August 18, 2023

Re: Bedrock Development at Paseo Del Norte and Woodmont Ave. NW
Erosion and Sediment Control Plan
Engineer's Stamp Date 7/31/2023 (C09E011B)

Based upon the information provided in your submittal received 7/31/2023, the above referenced ESC Plan is approved to be included in the SWPPP.

**TEMPORARY EROSION AND SEDIMENT CONTROL PLAN**

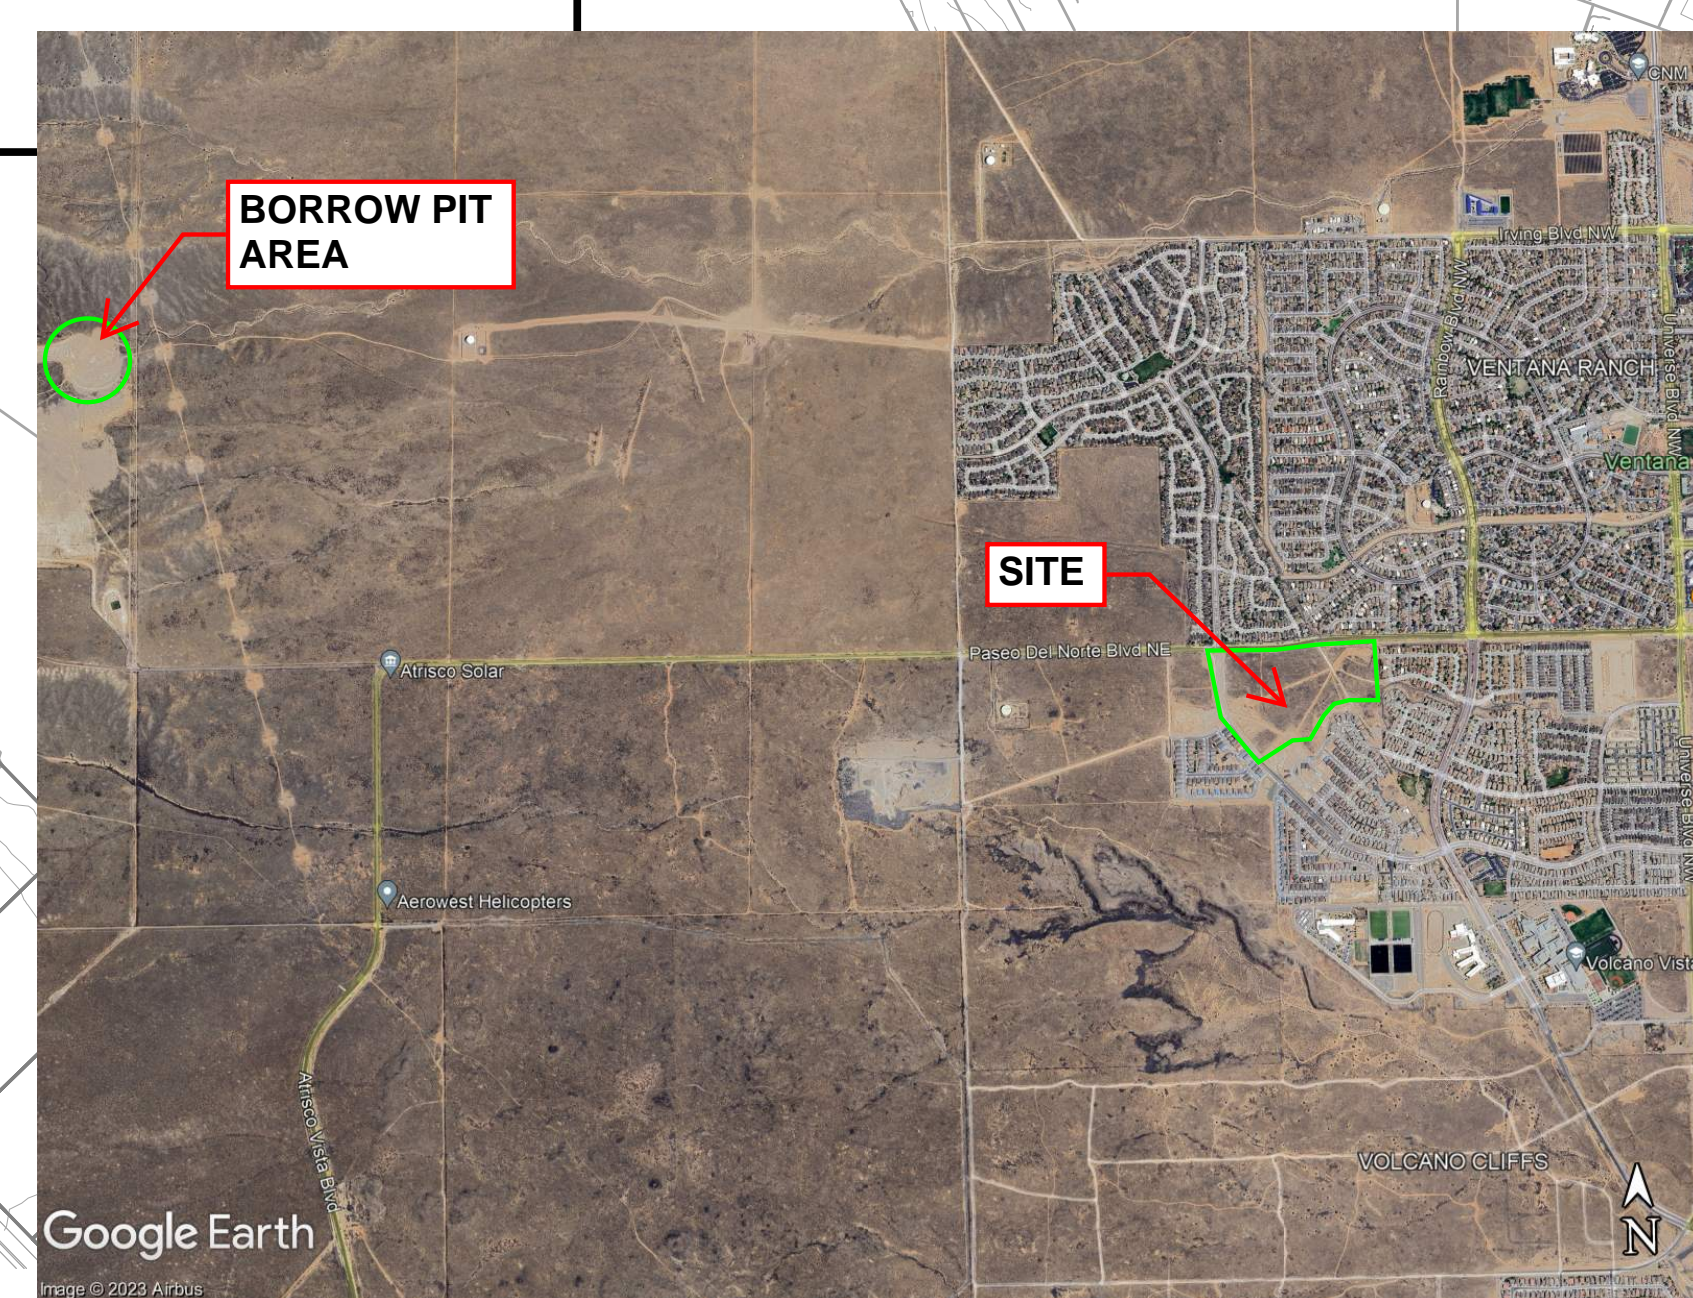
1. The ESC Plan cannot be approved until after Hydrology approves the G&D Plan for each specific purpose, Site Plan, Grading, Building Permit, and Work Order. The only purpose Hydrology has approved so far is Grading Permit. The existing and proposed grades must be shown on the ESC Plan and they must agree with the Grading Plan approved by Hydrology (CGP 7.2.4.b.ii).
